Medworth ISH2_12 April_PT2

FULL TRANSCRIPT (with timecode)

**Figure 10.1i**  
**New Bridge Lane access design**

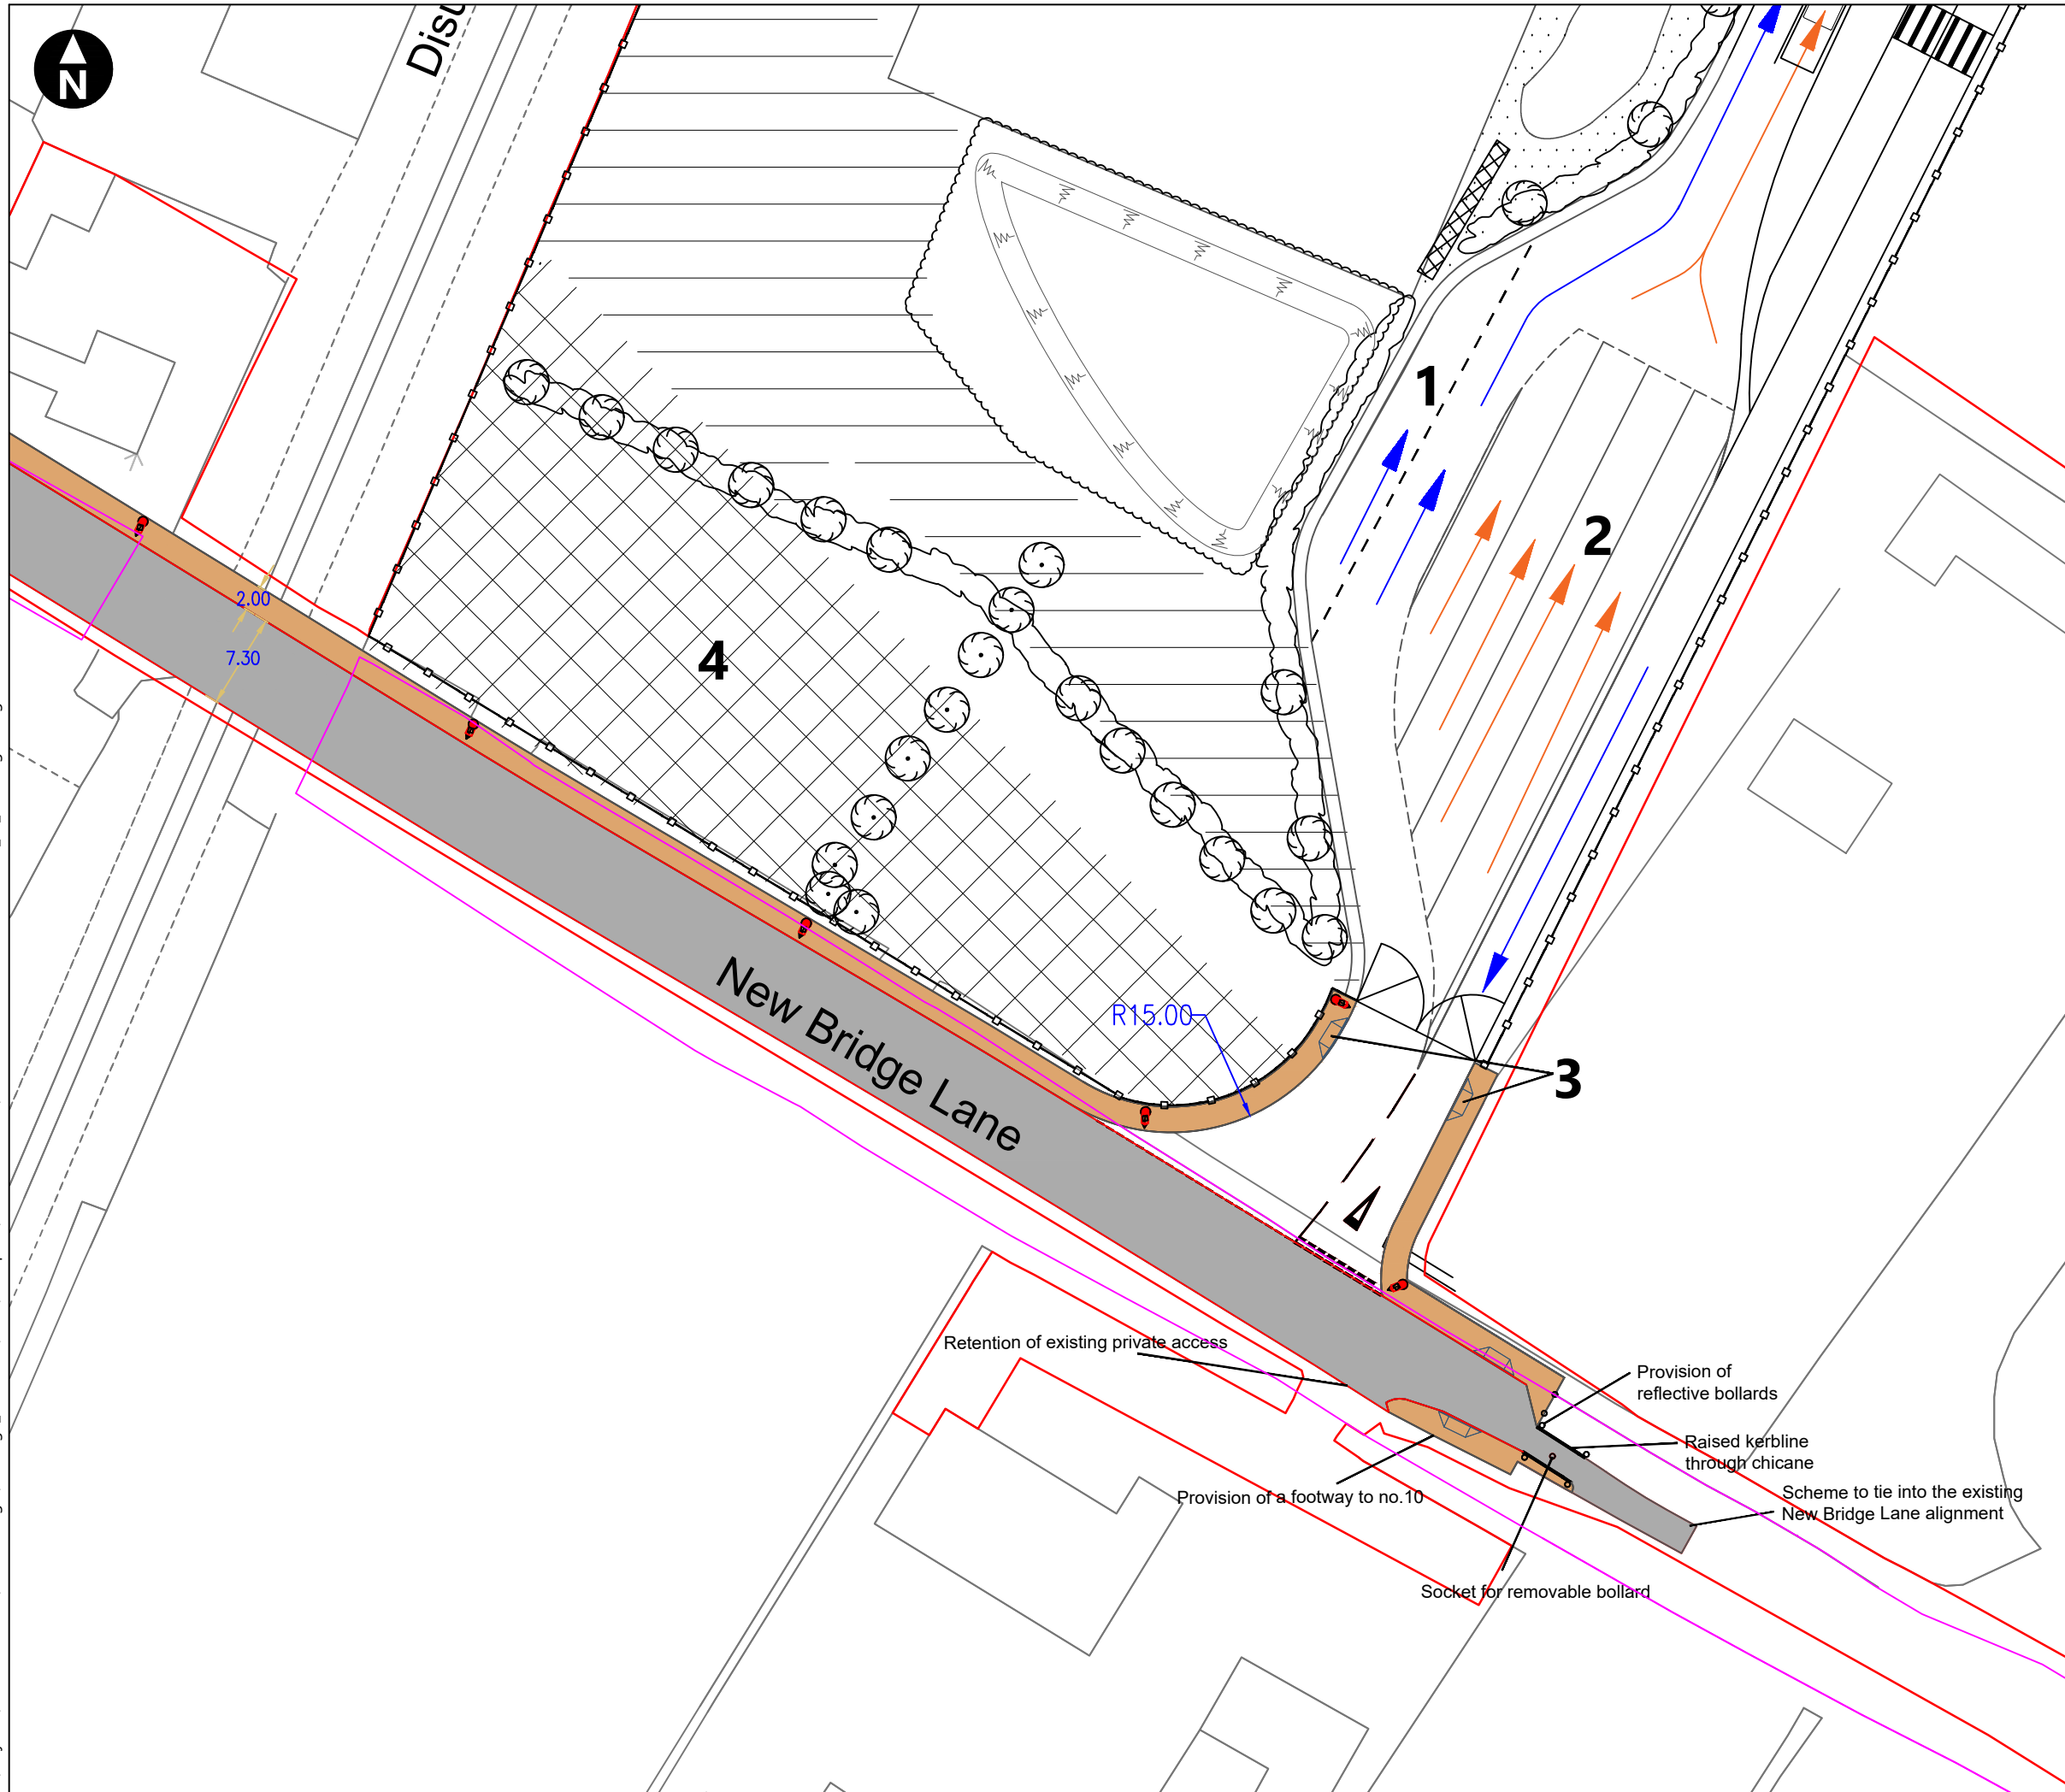
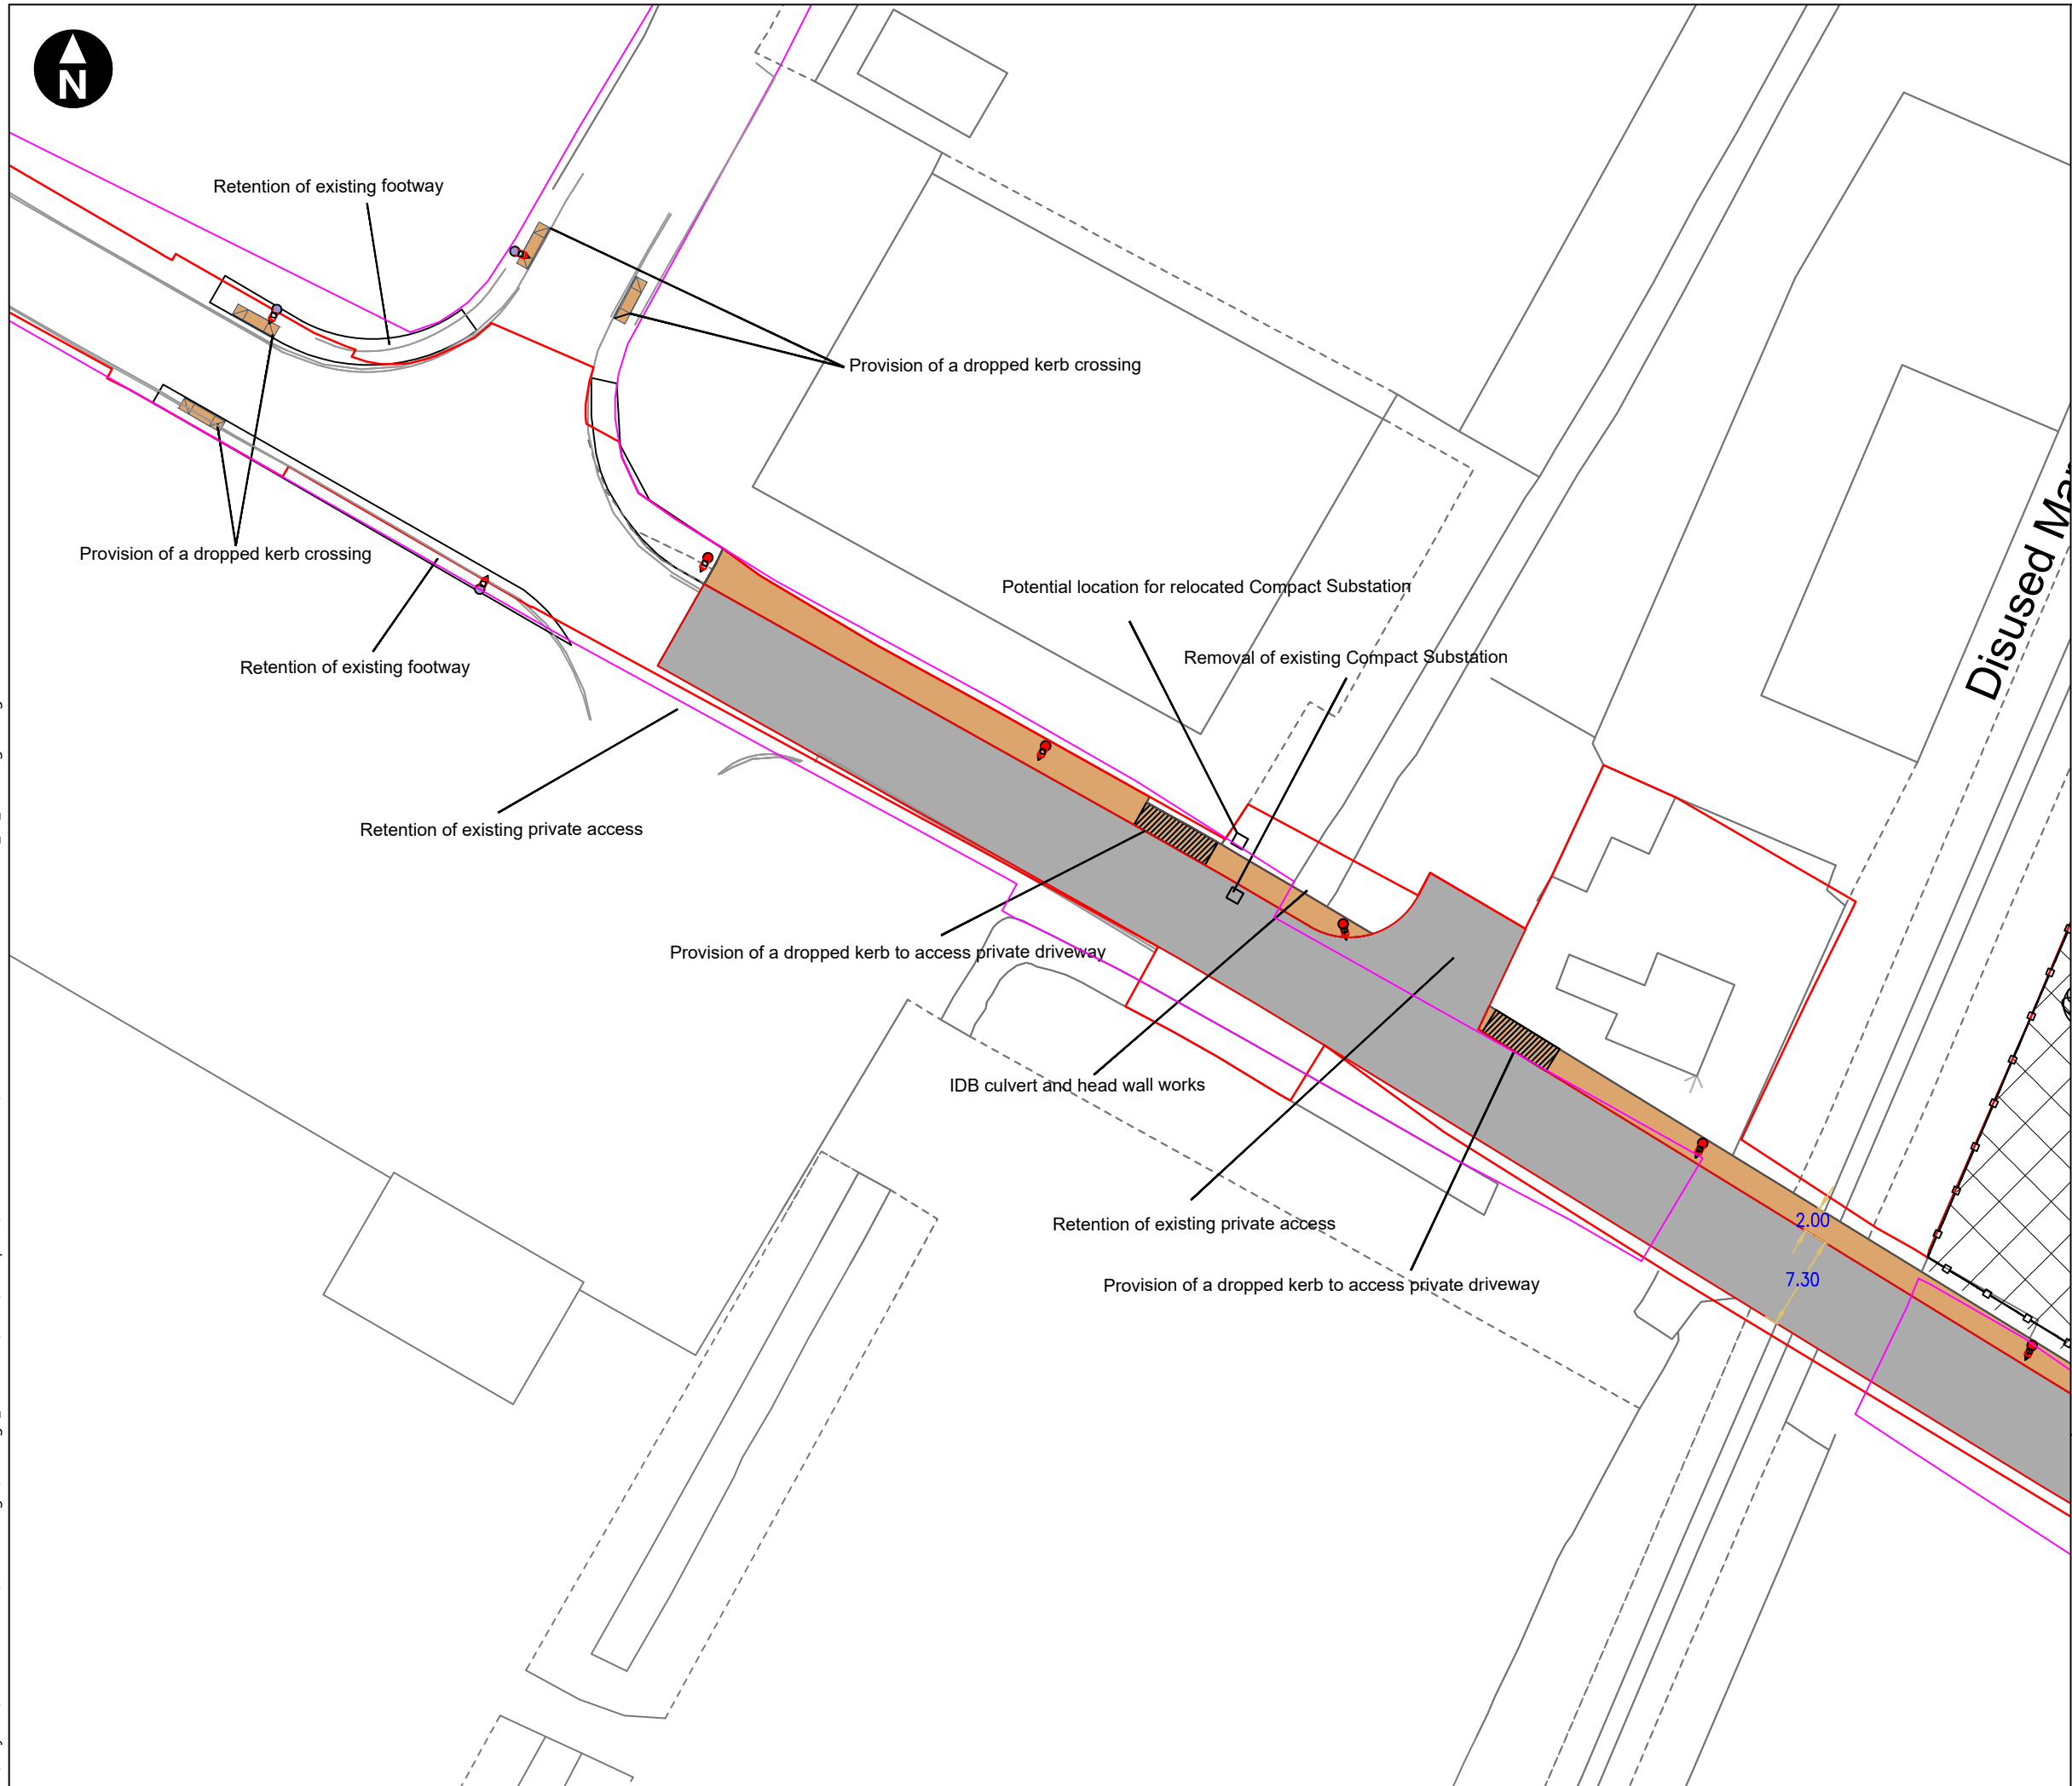
We regard this as quite an important issue because we think it does fundamentally affect the deliverability of the scheme, both with respect to new bridge lane and the widening of that and the provision of a safe and appropriate junction at the new bridge Lane Cromwell Road Junction. Now, I'm not gonna say any more about the substance of that, but that is an issue which we want to have the ability to contribute to. And if that's to be tomorrow, so be it. Um, I'm not available to attend tomorrow and I don't think my team can physically be here either.

That doesn't to me seem to cover the requirement to be involved in the design and approval of more substantial work, such as those on new Bridge Lane, which would be covered by Article 11 of the DCO. And that is a substantial reconstructing of a road which we would like to be properly protected when we're involved in.

It's not very clear on the screen. I was just trying to clarify that the hatched area that covers works for a doesn't cover the entire length of Newbridge Lane. It stops at a point slightly to the south, slightly to the southeast of the proposed site, but it doesn't go all the way down to the a47. That's the point I'm trying to make.

Article seven, schedule two highways access. Description. It's still only provides the most bare bones of control. Written details of the access improvements as part of the work we set out. Repeated in detail the more extensive control that we think is necessary. That's that's observation number one. Observation number two is a matter of drafting within the access vision that that article, which is that seven two.

Refers to submission to an approval by the relevant planning authority. Now, clearly it seems to me that needs to be amended to say the relevant highway was the authority.

For the applicant. I think Masako was being slightly unkind in his characterization of our response, if I may say so. The applicant in response to the concerns raised, did deadline one submit and updated figures showing the improvement works to Newbridge Lane and Al Gore's way and construction traffic management plan was updated. Outline plan was updated and submitted at deadline one with with additional detail around the process and commitments around engagement and consultation with the Cambridgeshire.

Misleading as a result of the way that the requirement is titled Highway access. But the intention of Part two of requirement seven is to cover all of the totality of the improvement works captured by what number four and four be. So new bridge lane. And our goals are not just specific accesses, so stop paragraph one deals with new accesses and paragraph two is intended to deal with improvement works to new bridge lane. And of course we hope that's helpful.

For the applicant. Yes. So we're happy to try and provide some clearer figures. What we might be able to do is to separate out the layers so you're not seeing all the layers over there.
